July 27, 2017

Re: Hagstrom Residence Critical Areas Report, Response to Peer Review Comments

The Watershed Company Reference Number: 160735

JOB NUMBER: 160735  
SHEET NUMBER: W3 OF 7

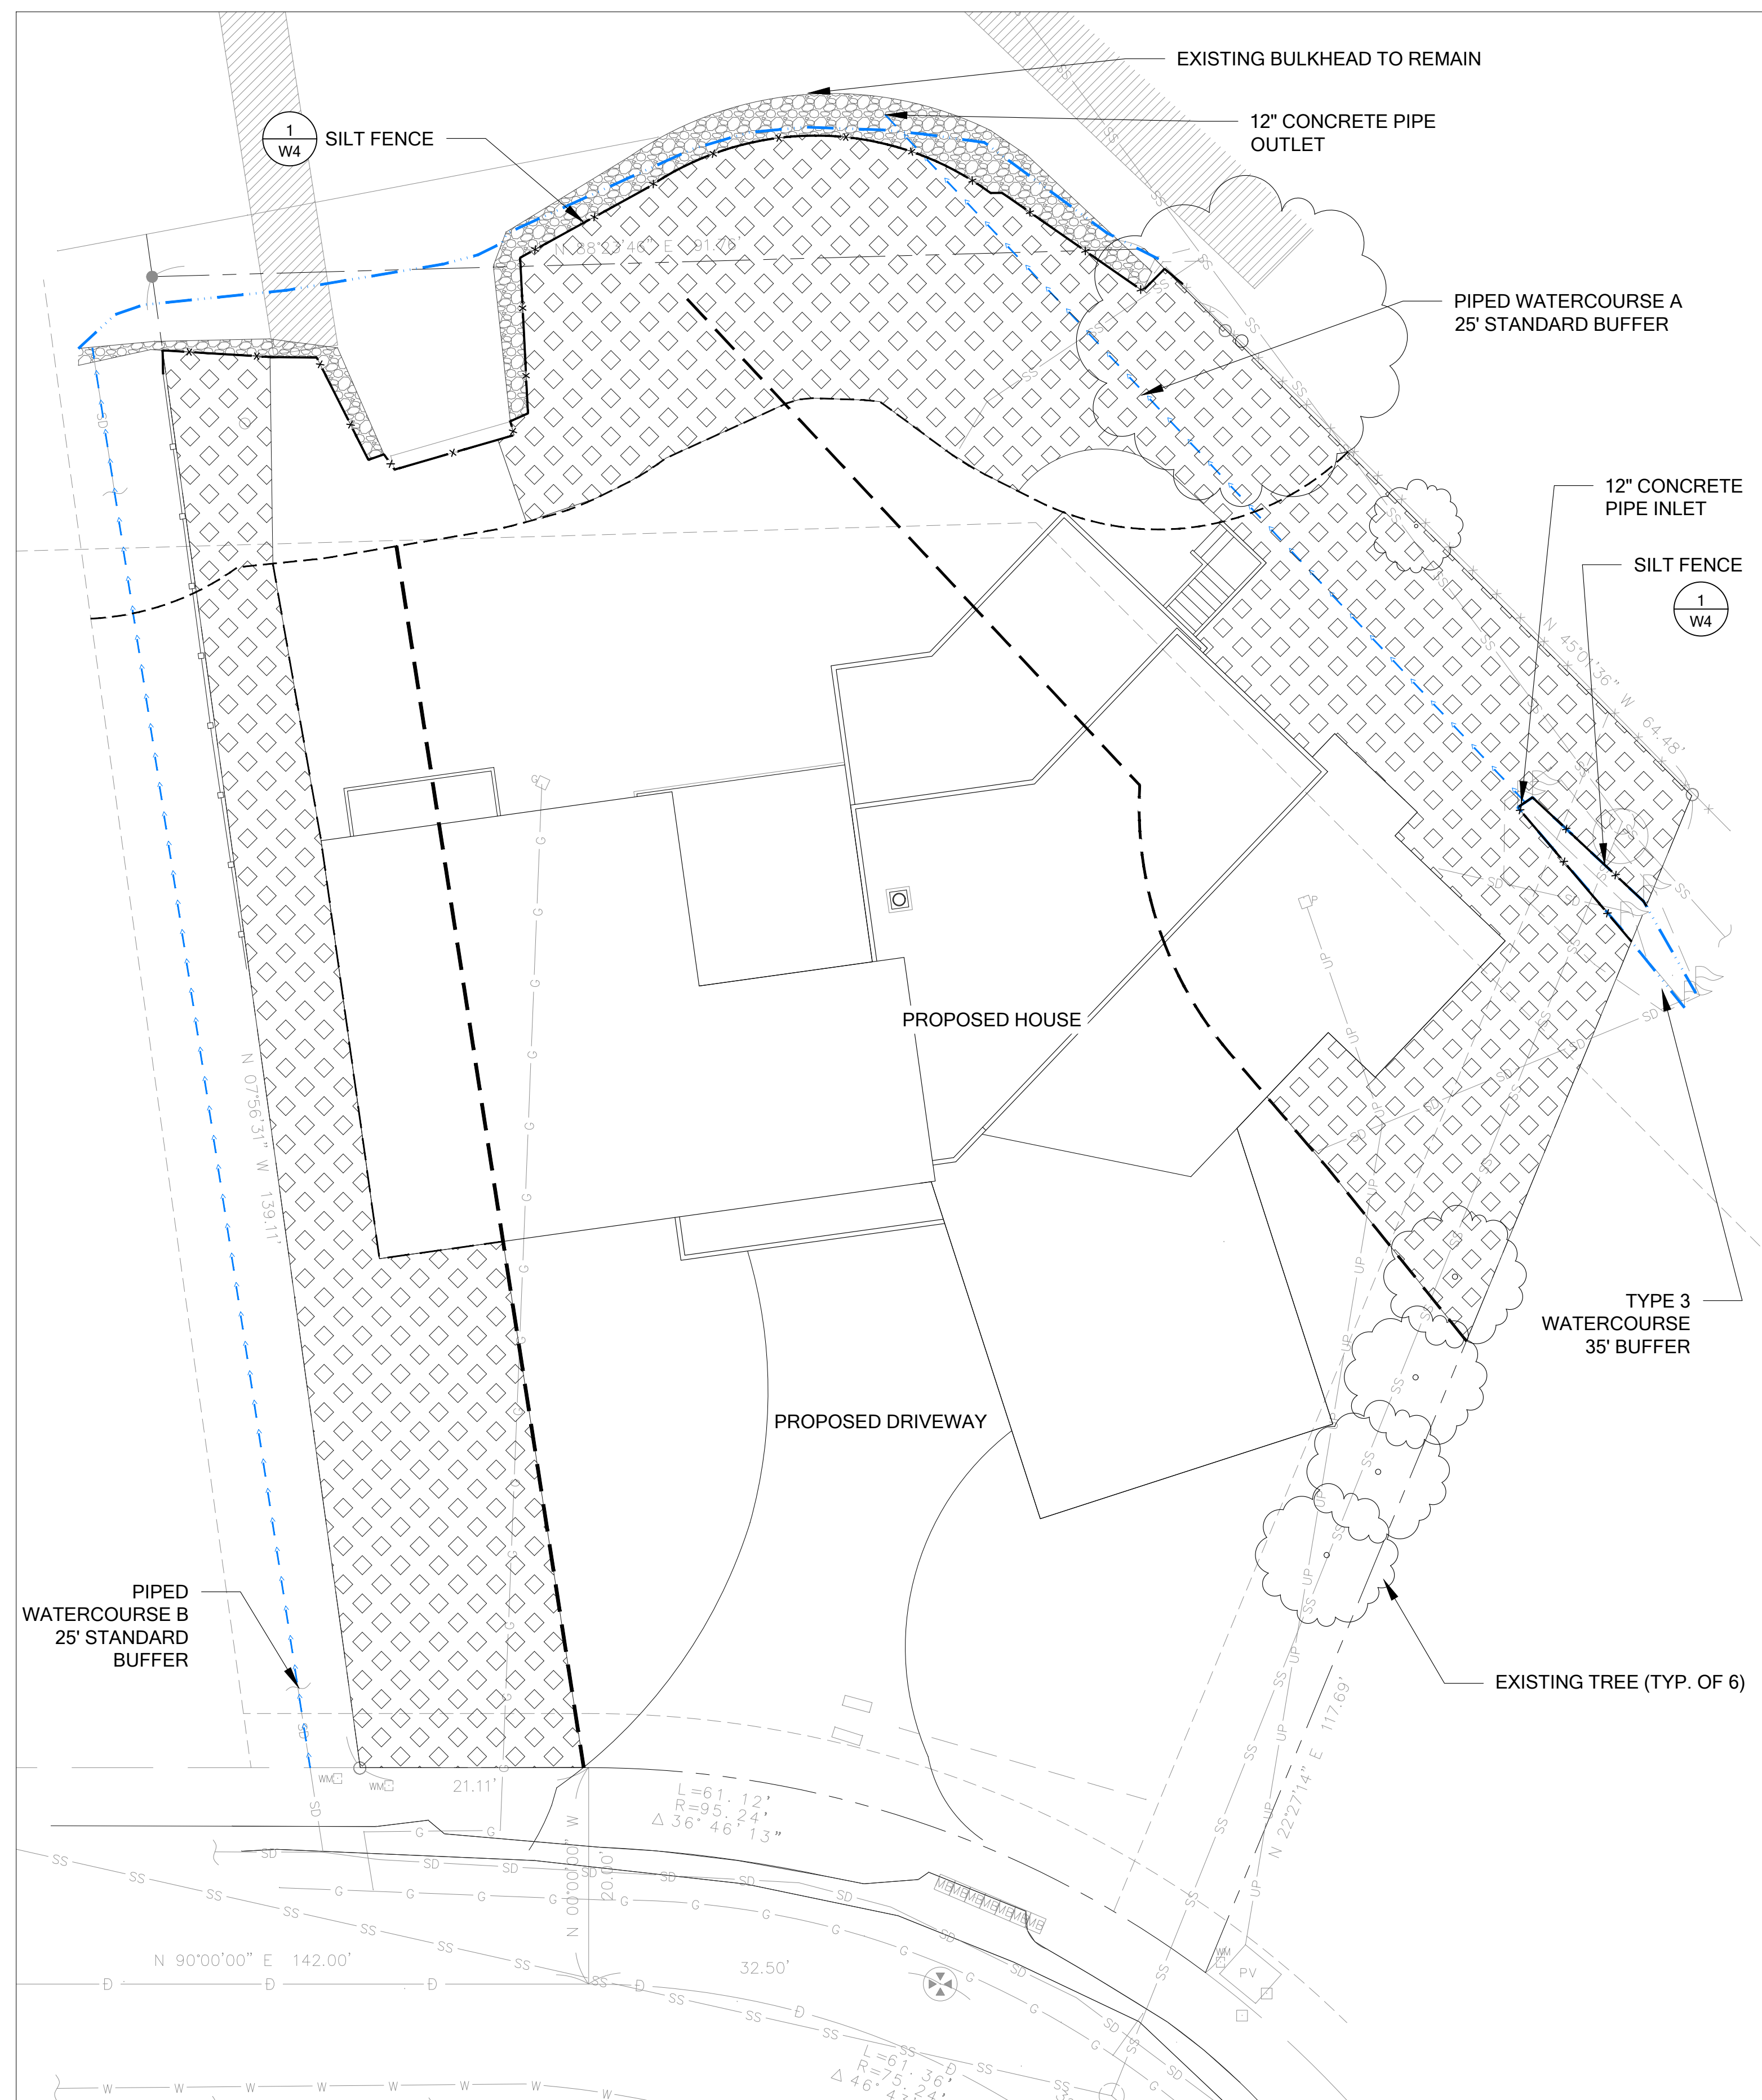
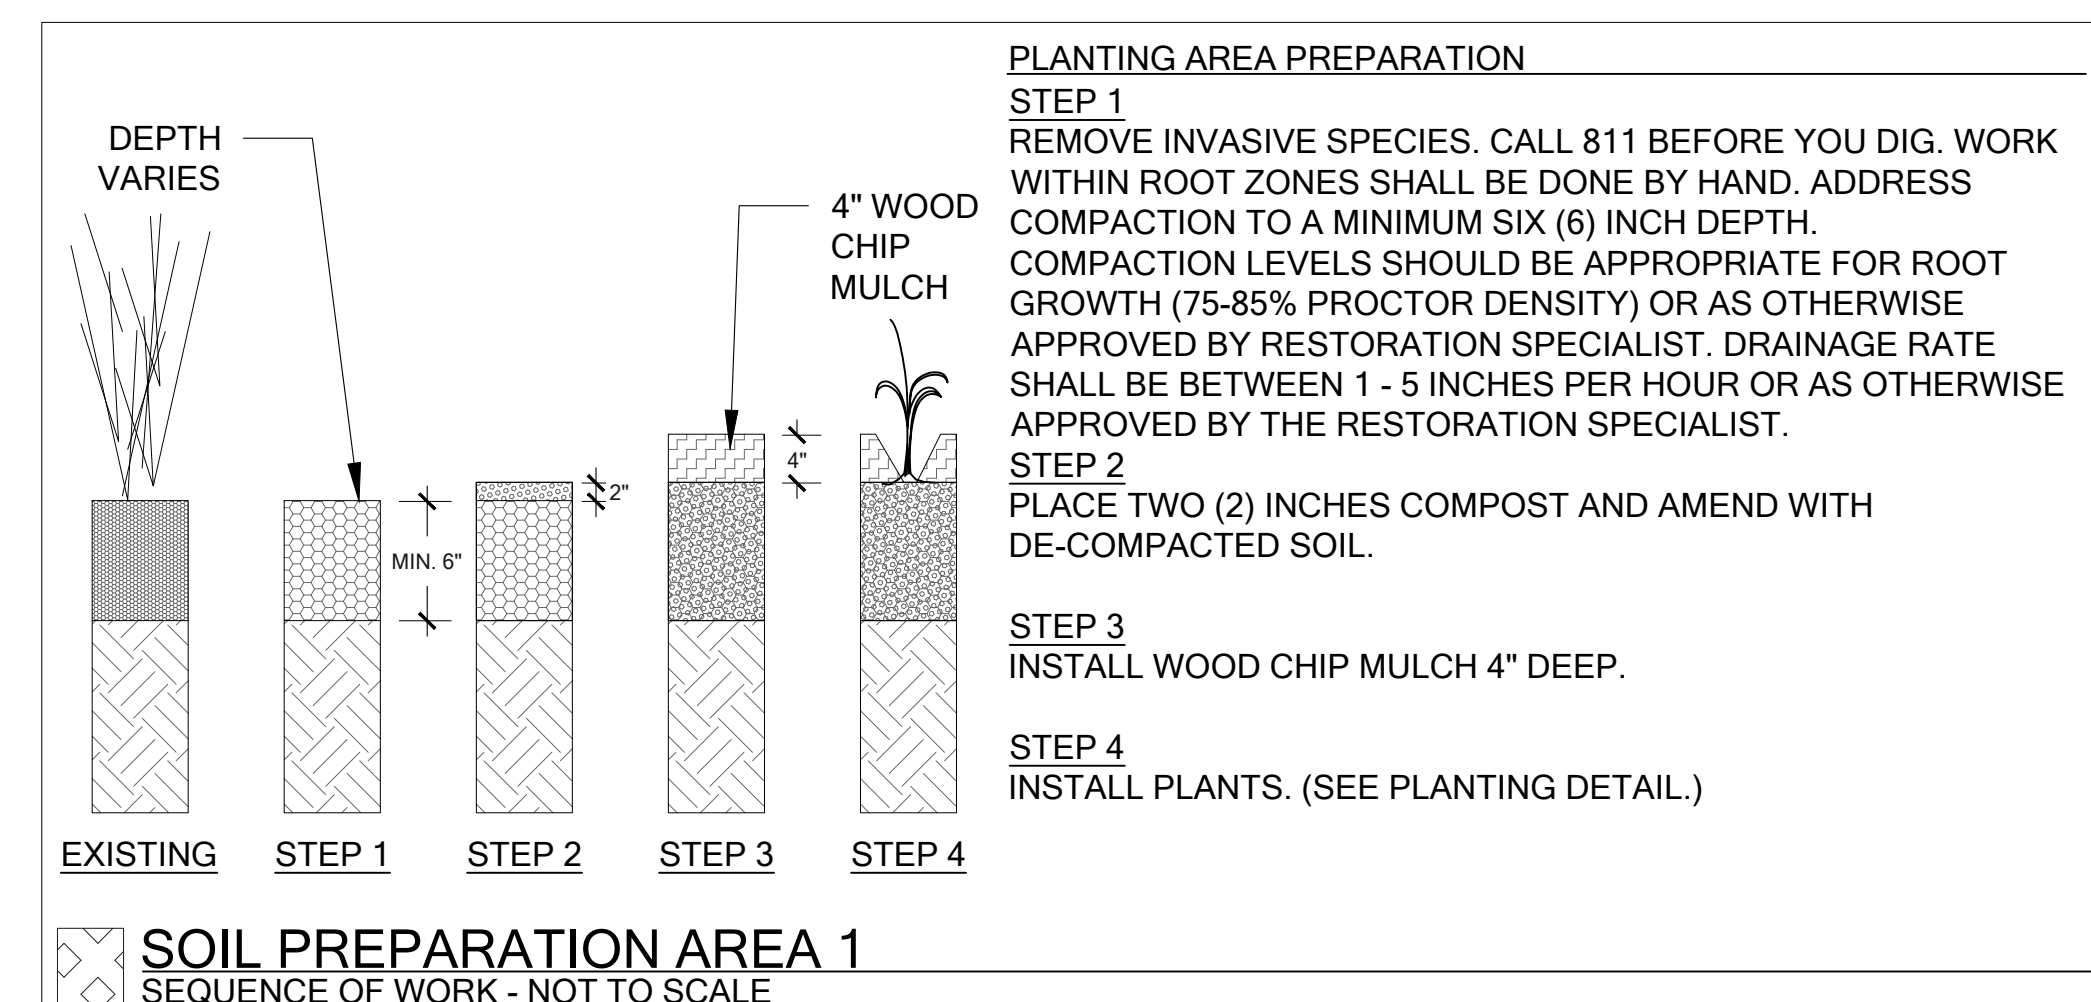
Concern – On sheet W3 of the drawing set the legend lists the buffer enhancement area for shoreline setback mitigation at 1,819 SF, but page 10 (section 5.0) of the critical area study lists that enhancement area at 1,908 SF.

The correct area of shoreline setback mitigation area is 1,908 SF. The CAR has been revised to correct the inconsistency.

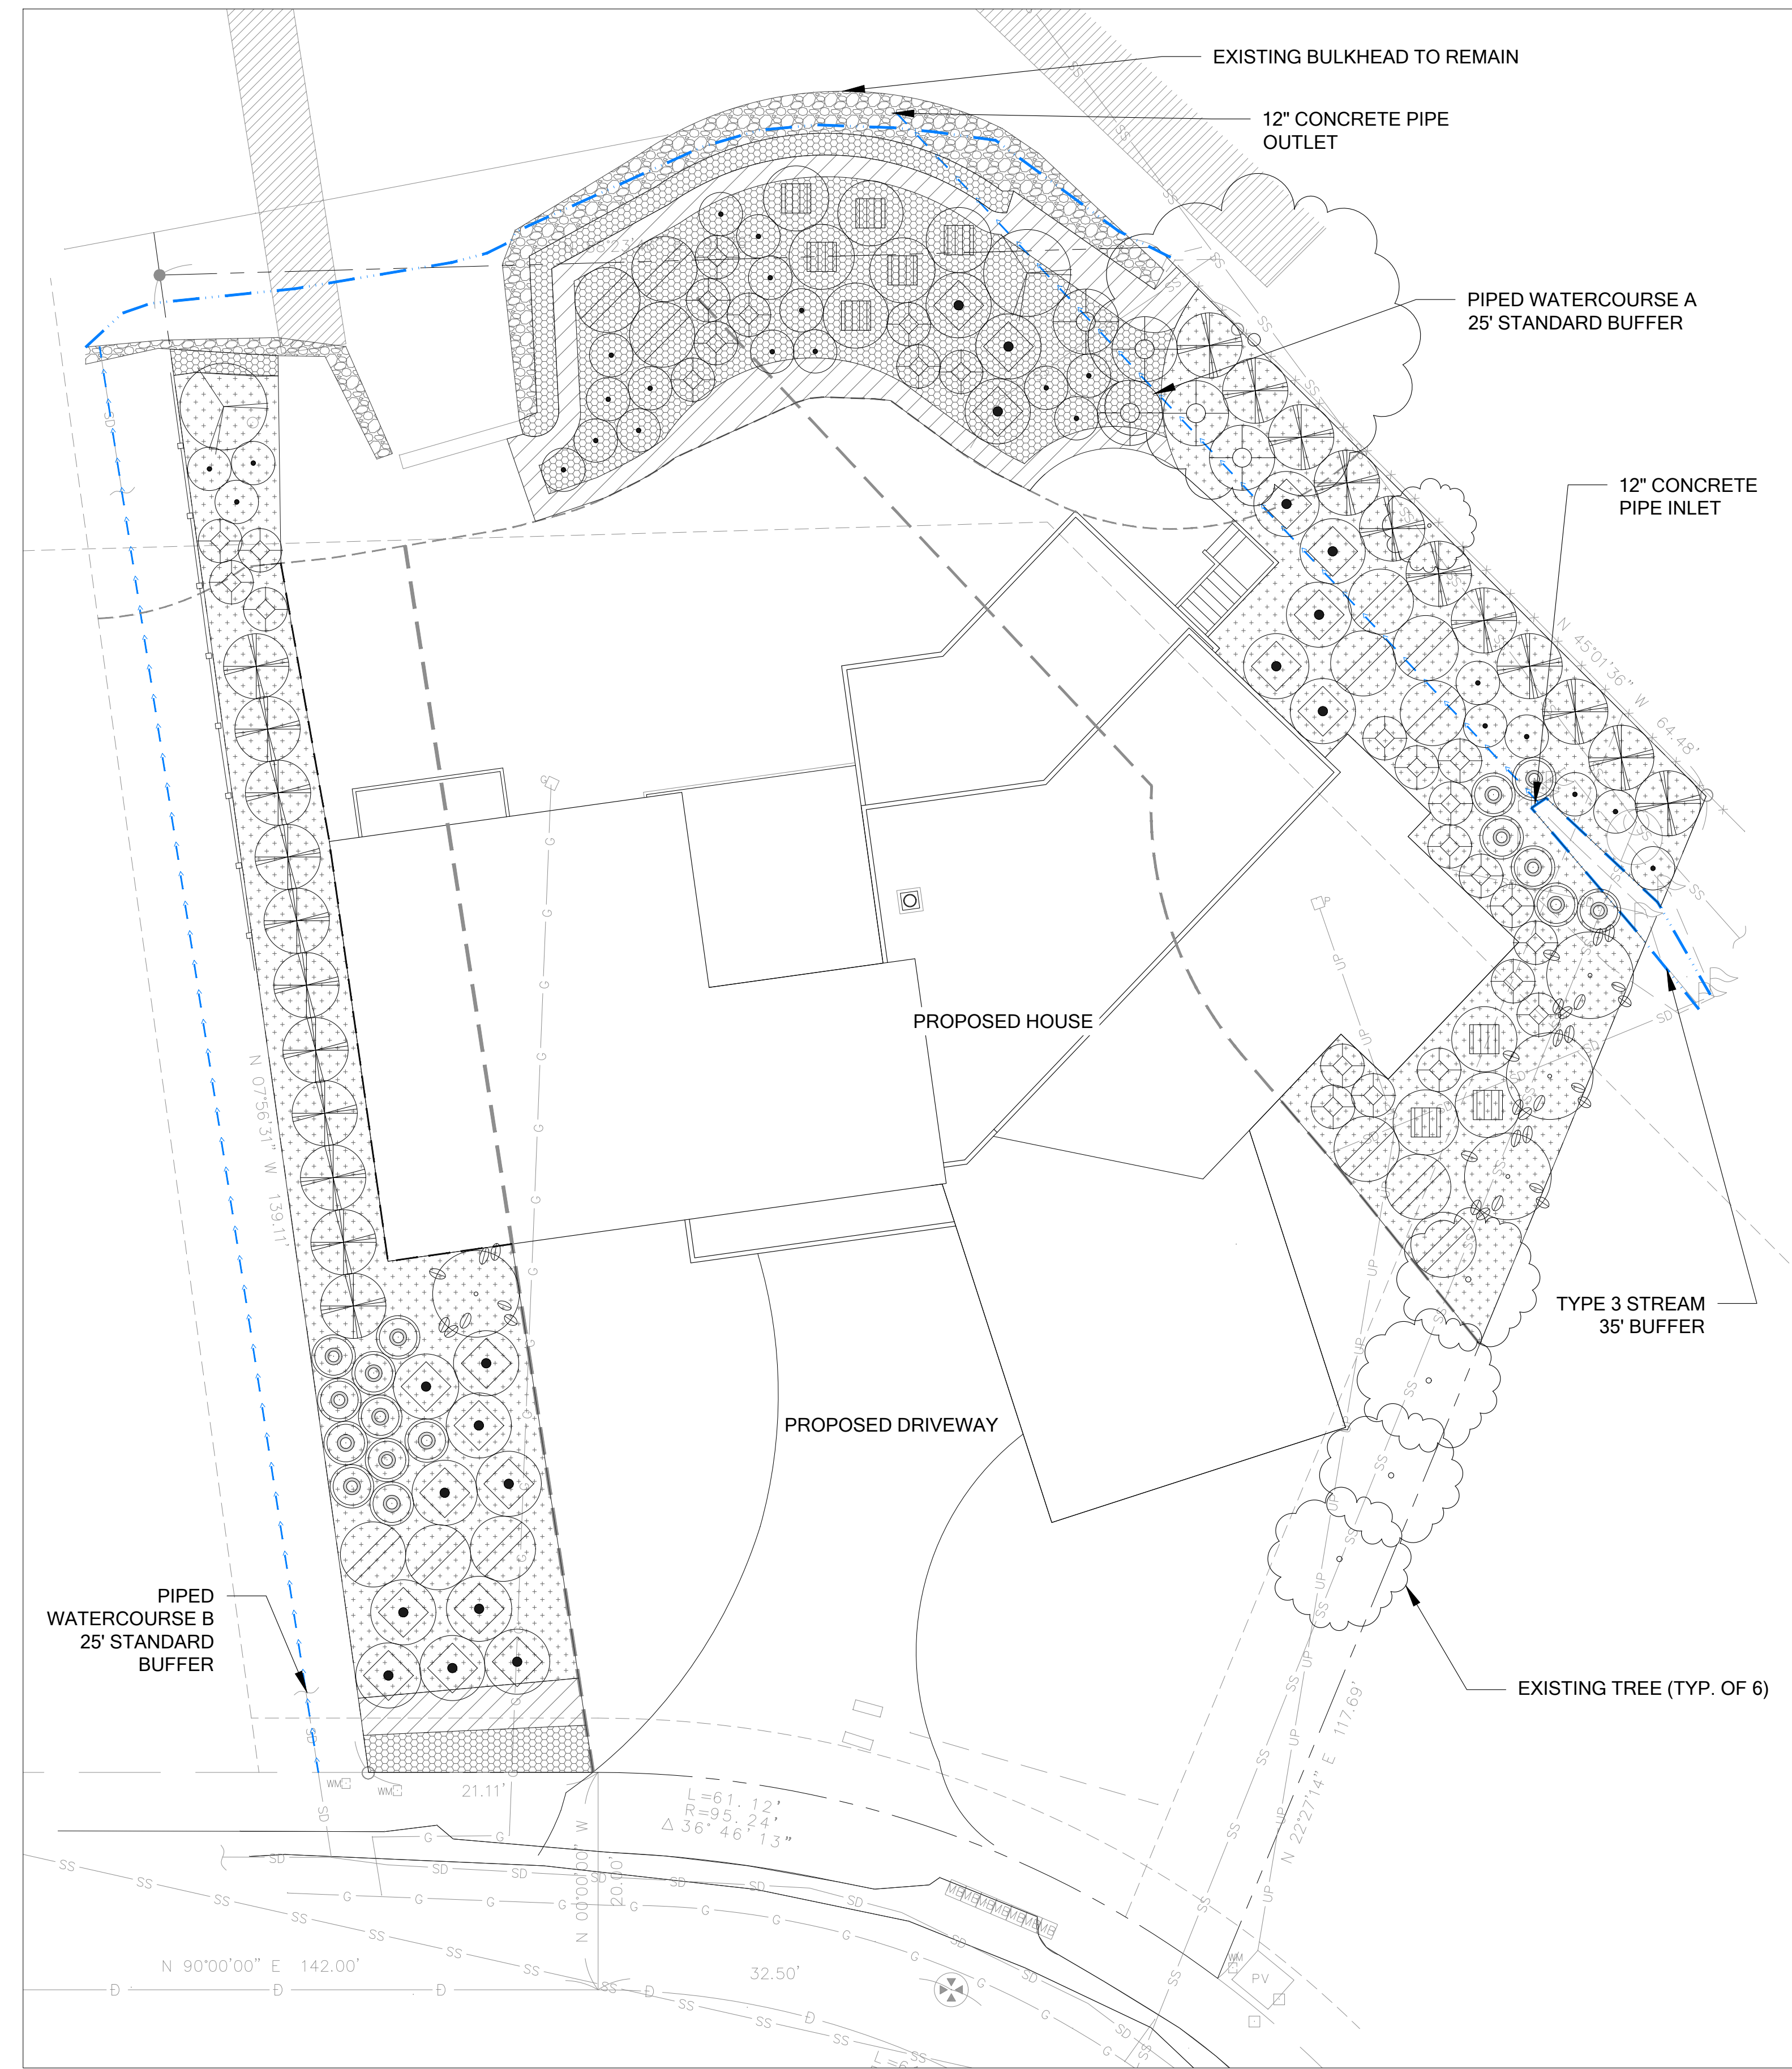
On the "second" sheet W4 of the drawing set (assuming it is meant to be sheet W5) there are ten (10) shrubs listed in the planting schedule, but on page 14 of the critical area study (section 6.1) it states that "nine native small tree/shrub species and five native groundcover species are proposed in the mitigation area."

Also on "second" sheet W4 hatched areas for groundcovers are shown beneath proposed shrub plantings. If the quantities listed for groundcovers in the planting schedule are calculated to be planted at 24" O.C. across the entirety of these hatched areas, this would result in too many plants being planted on the site. This could be mitigated if the quantities been adjusted to leave room for the other plants on the plan.

There correct number of proposed shrub plantings is ten. The CAR has been revised to correct the inconsistency. The duplicate plan sheet numbers have been corrected.

The planting quantities and/or densities have been recalculated as requested. Groundcovers in the watercourse buffer enhancement areas, which include sword fern and low Oregon grape, will be spaced at 48" on center. Groundcovers in the shoreline buffer enhancement area, including kinnikinnick, western larkspur, and Roemer's fescue, are smaller species, which will be installed at 36" on center.
